CONSULTATION RESPONSE:

Application No. 2022/62/91911/E – 47 Houses, Cliffe Hill, Denby Dale

TYPE E2

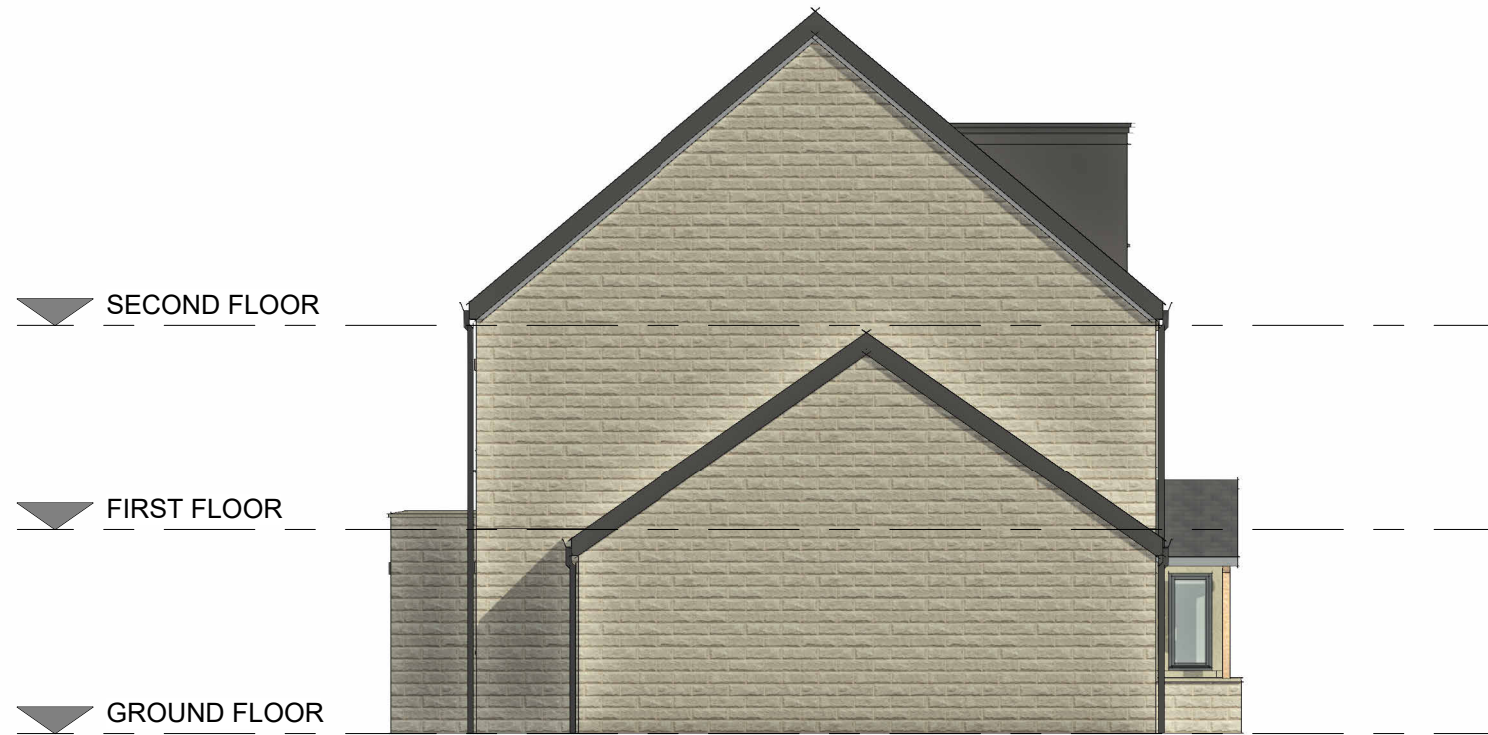
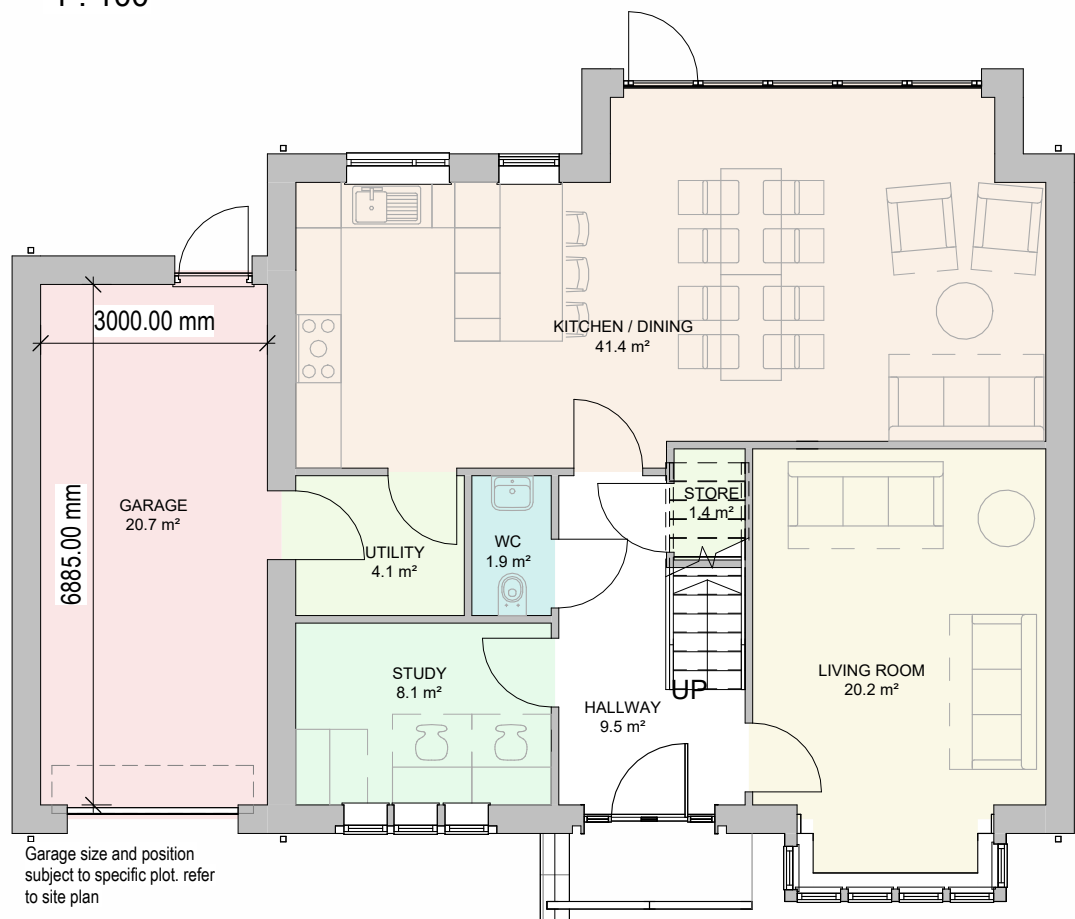
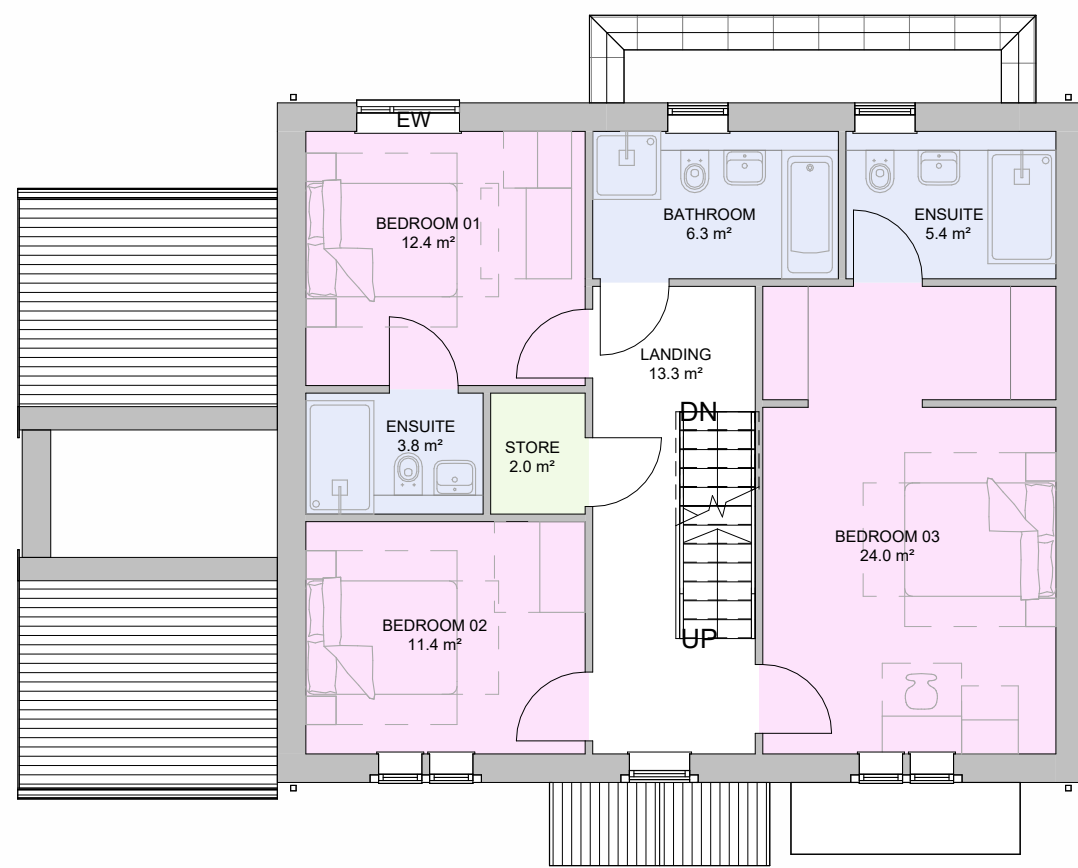
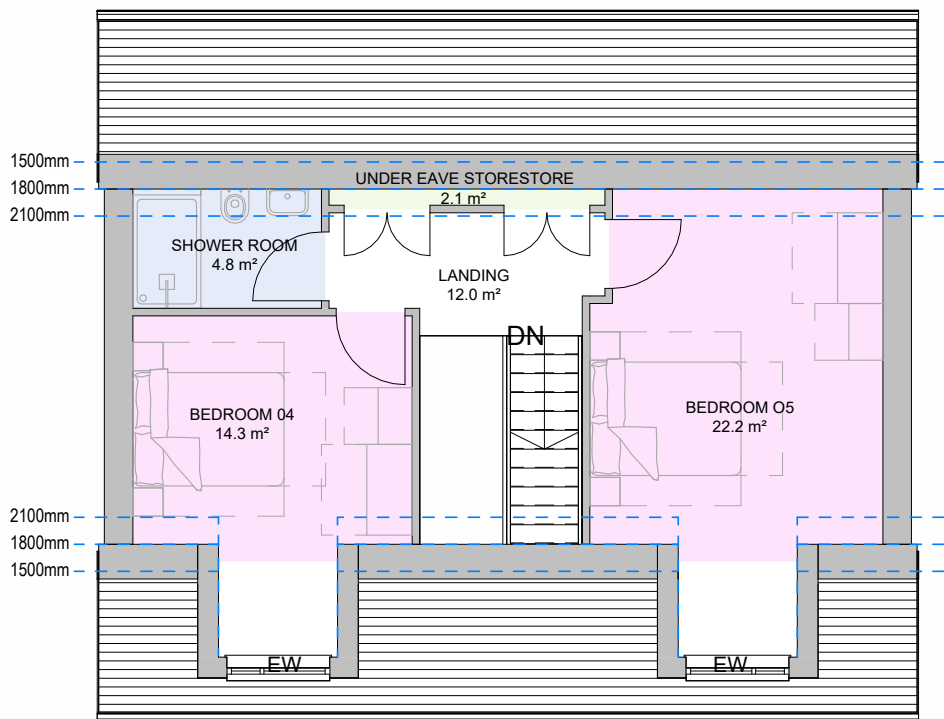
- We query the size of garages as no dimensions are shown on the drawing found on the web site. The five most popular family cars last year were 5'11 in. wide and 14ft 1in long. Garage design allowances appear to have not kept up and width has remained at 6ft. 11in. Any driver needs more than 6in. to exit the side of a vehicle once inside the garage. A recent RAC Foundation Study found that 2/3 of people do not use their garage for the car, but for storage and this creates chaos on developments. Counting a garage as a 'parking' space appears to be totally over optimistic and doing so is likely to cause overspill onto estate roads/pavements. This is further exacerbated by the apparent lack of visitor parking. What happens when the 'work's van' comes home or a caravan/motorhome? **If garages are unusable, the developer cannot claim to have met the Authority's Highways Design Guide, Section 5.4 for parking spaces. The LPA should not be accepting inadequately sized garages as 'parking space'.**
